From: Christian Barrington [REDACTED]  
Sent: 06 March 2024 15:27  
To: Tom Nemeth  
Cc: Jenny Fawn-Telford; Michael Bradshaw  
Subject: [EXTERNAL] Re: Submission of Required Documentation for Planning Application CC/24/00390/FUL  
Attachments: 007.24 - 010 - P1.pdf; 007.24 - 001 - P2.pdf

Validation Officer  
DM Admin & Business Support  
Chichester District Council

I am writing in response to your letter regarding our planning application (CC/24/00390/FUL) for the installation of odour mitigating filtration and extraction at Unit 13, St James Industrial Estate, Chichester PO19 7JU.

007.24 - 001 - P2

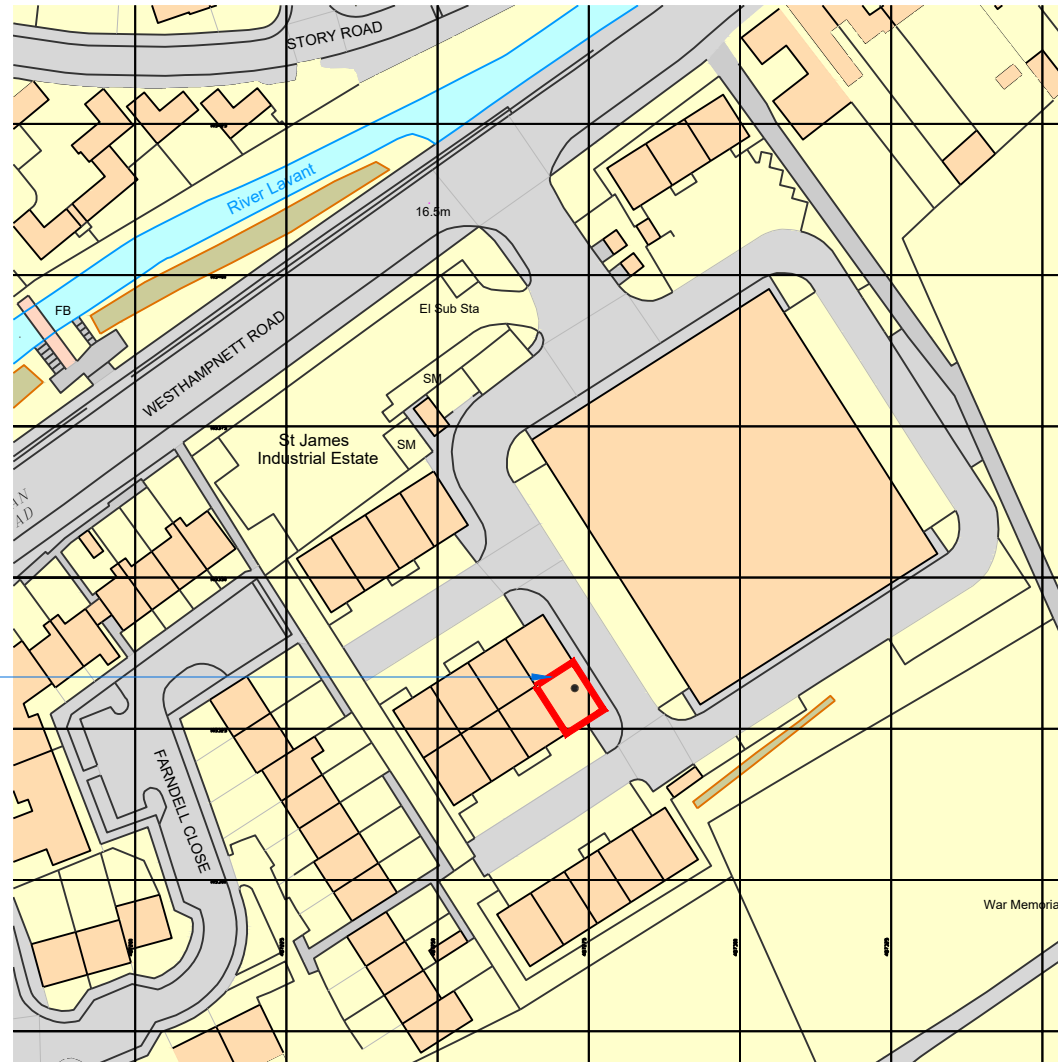
Please provide a site location plan (1:1250) application site edged in bold red (as presented on 007.24-001-P1)

Please amend 007.24-001-P1 relabelling from site location plan to site block plan.

Thank you for your email, and please find attached the documentation to the requested specification. Please do let me know if there's anything else you require.
